Arun District Council
Arun Civic Centre
Maltravers Road
Littlehampton
West Sussex BN17 5LF
Planning & Building Control General Enquiries
Tel: (01903) 737756 Fax: (01903) 730442
Dx: 57406 Littlehampton
Minicom: 01903 732765
e-mail: planning@arun.gov.uk
website: www.arun.gov.uk/planning

Application No: LU/5/22/PL
Site Address: 37 Griffin Crescent Littlehampton BN17 7LH
Description of works: Change of use from a single dwelling into two flats and rear two storey extension and rear dormer. This application is in CIL Zone 2 and is CIL Liable as flats.

Thank you for your internet representation made on 1st March 2022 which has been recorded as an objection with the comments as follows:

DRWG TITLE: **Proposed plans**

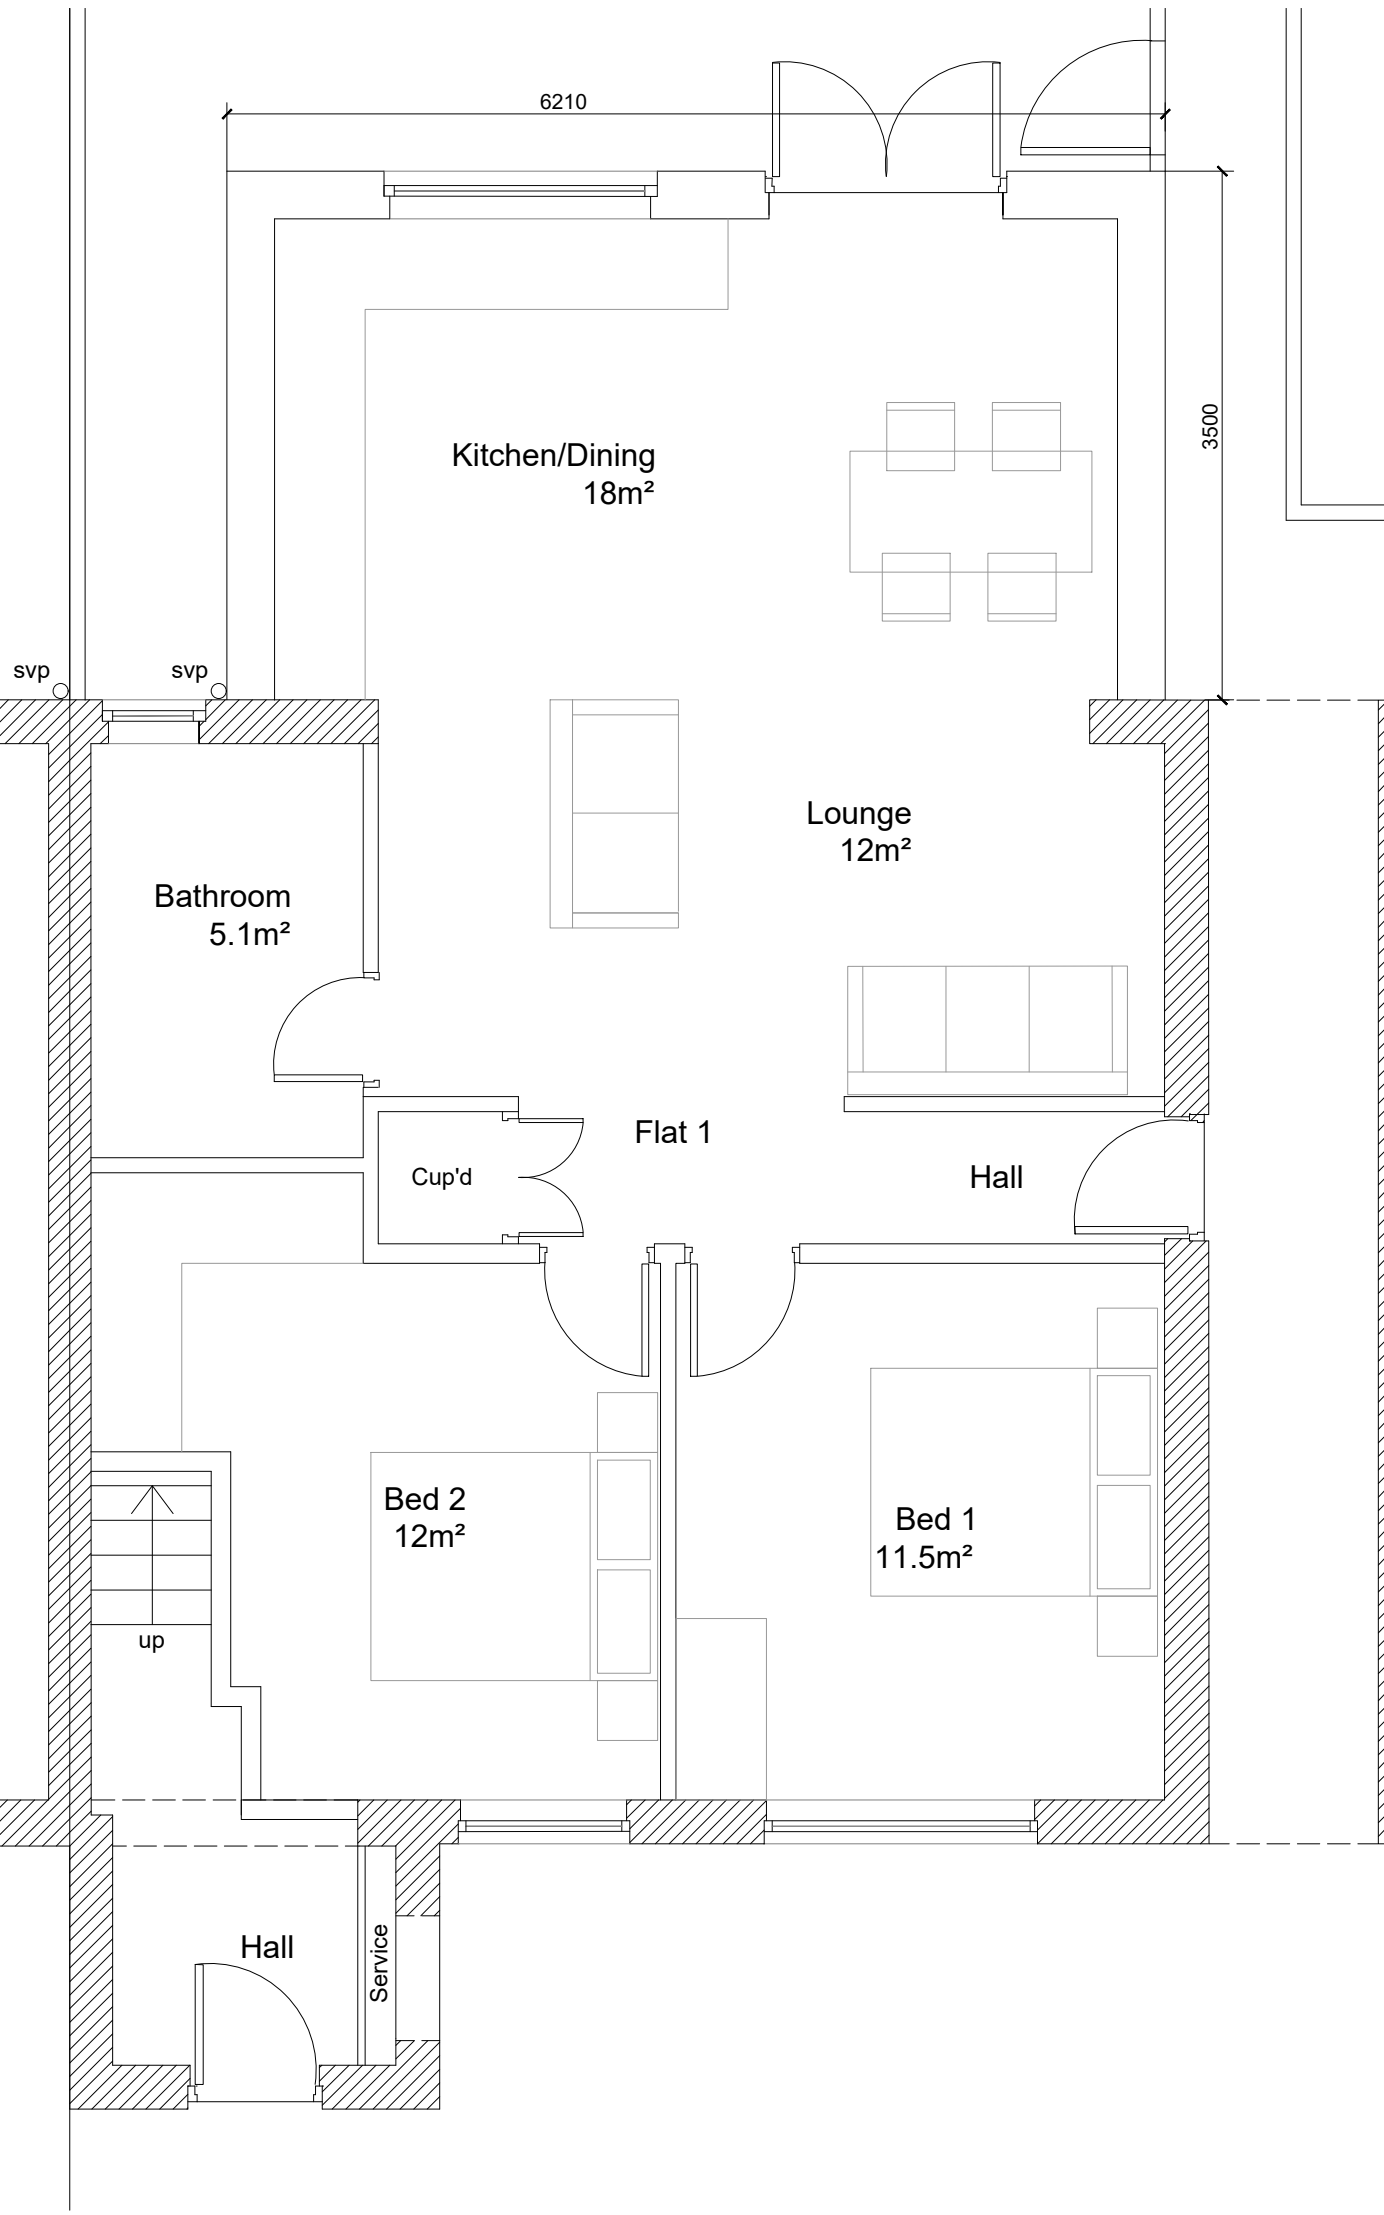
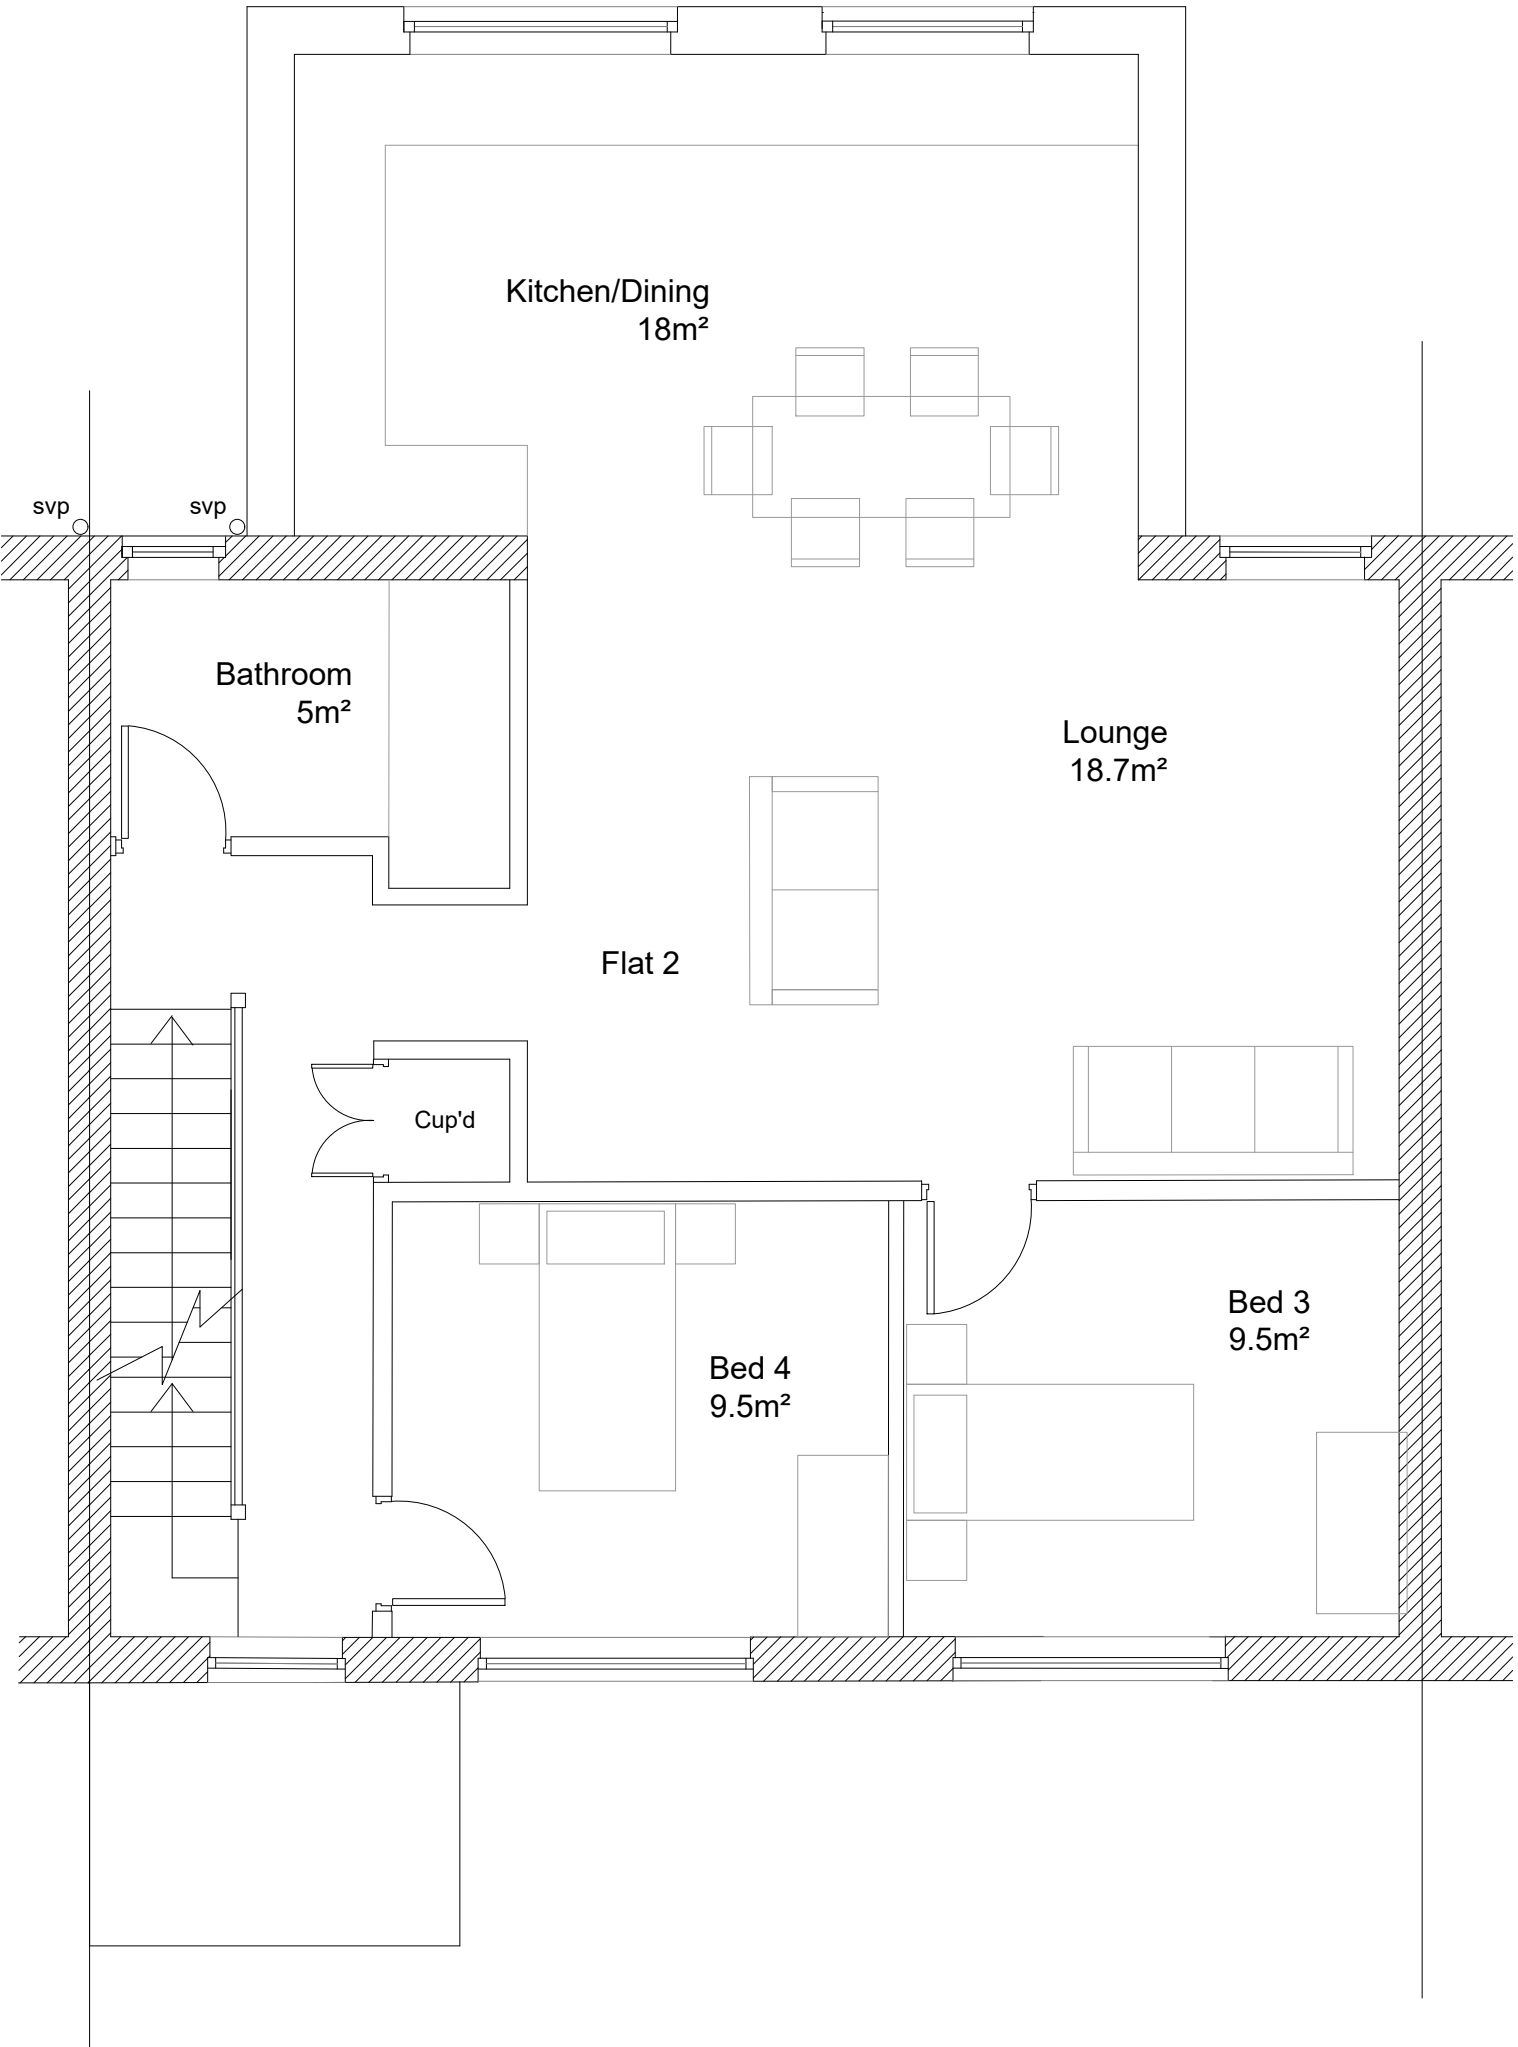
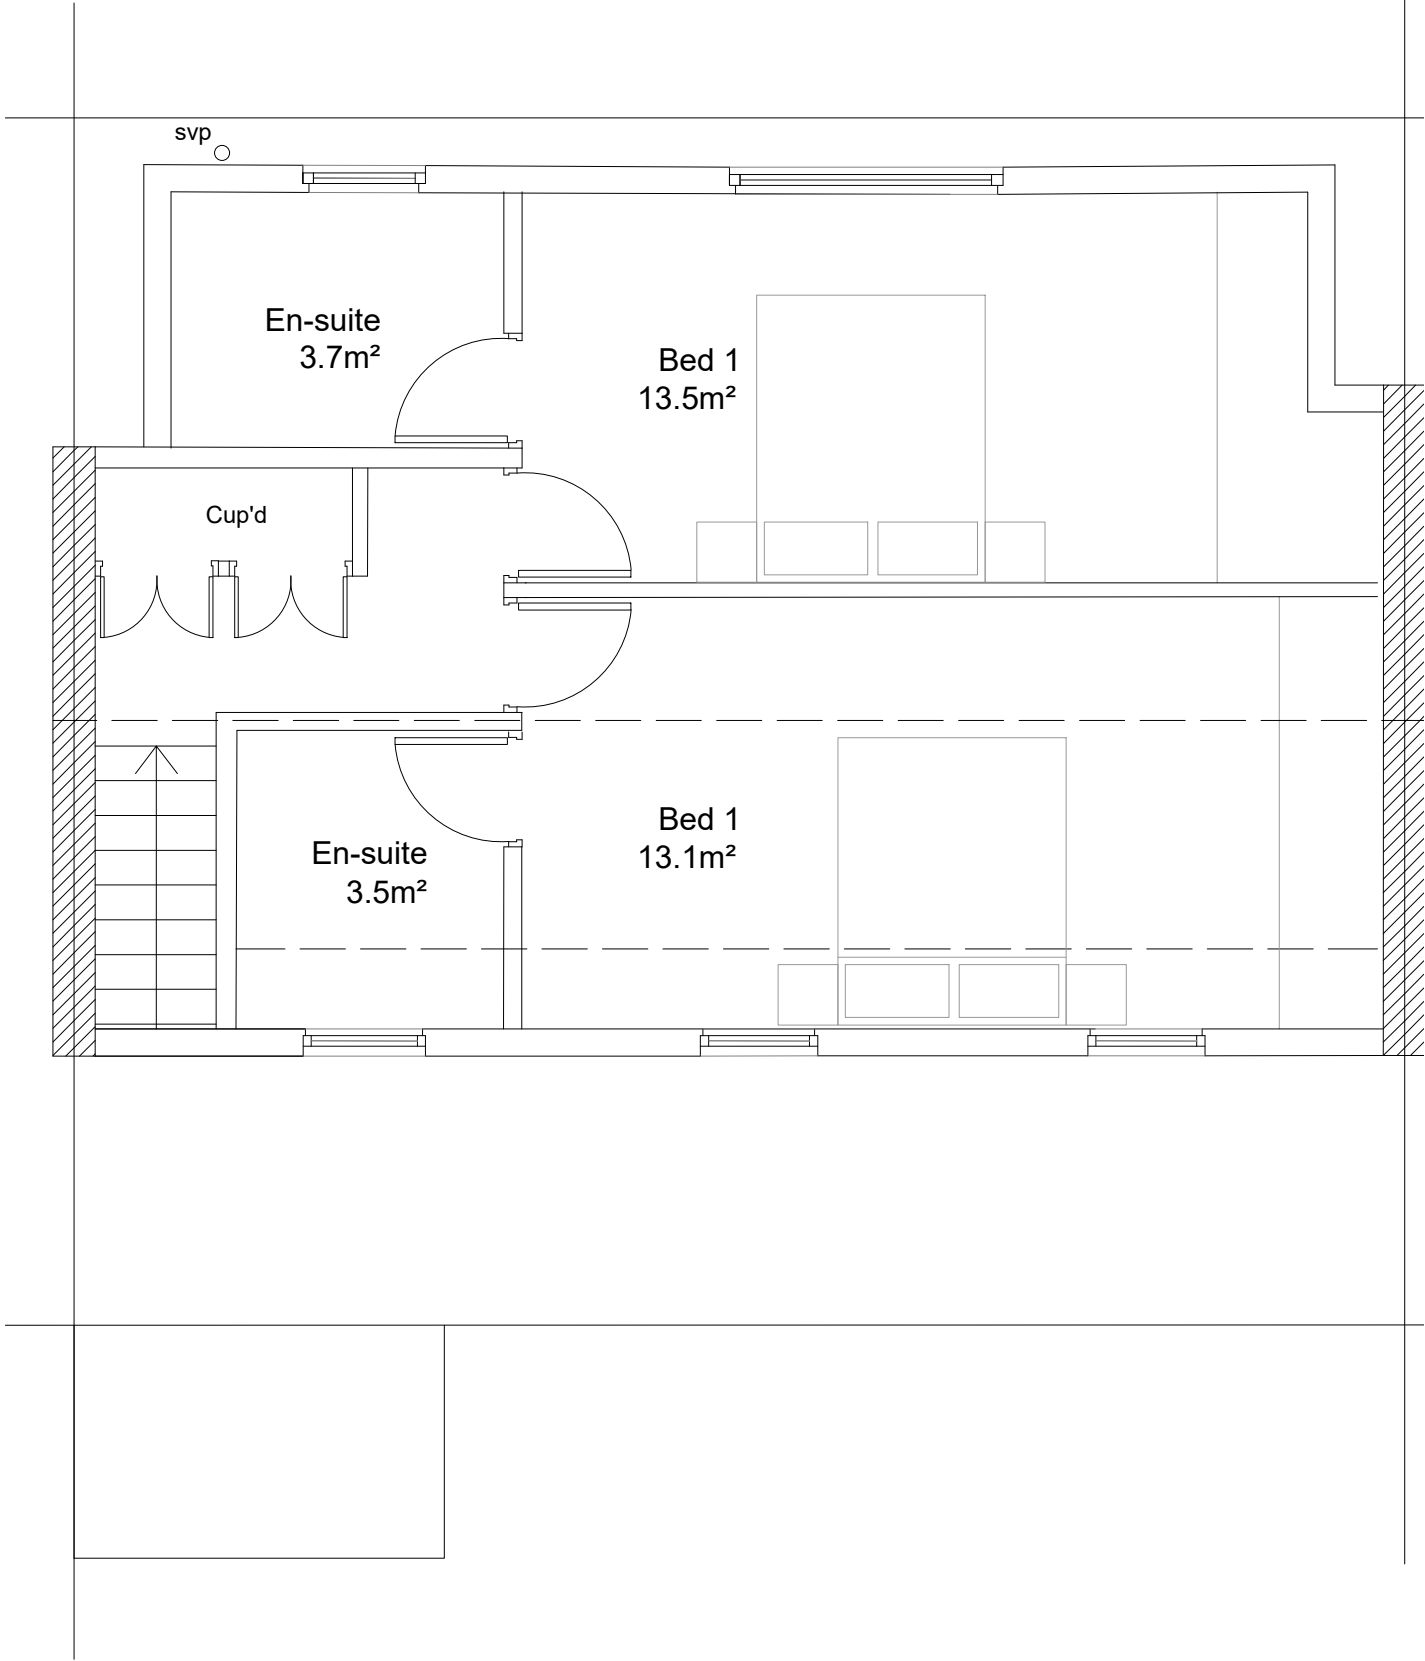
The Town Council's Planning and Transportation Committee considered this application at their meeting held on Monday 28 February 2022 and object to the application. Considered overdevelopment of the site and out of character in terms of its appearance compared with existing development in the vicinity. The accommodation on the ground floor also did not meet the space standards.
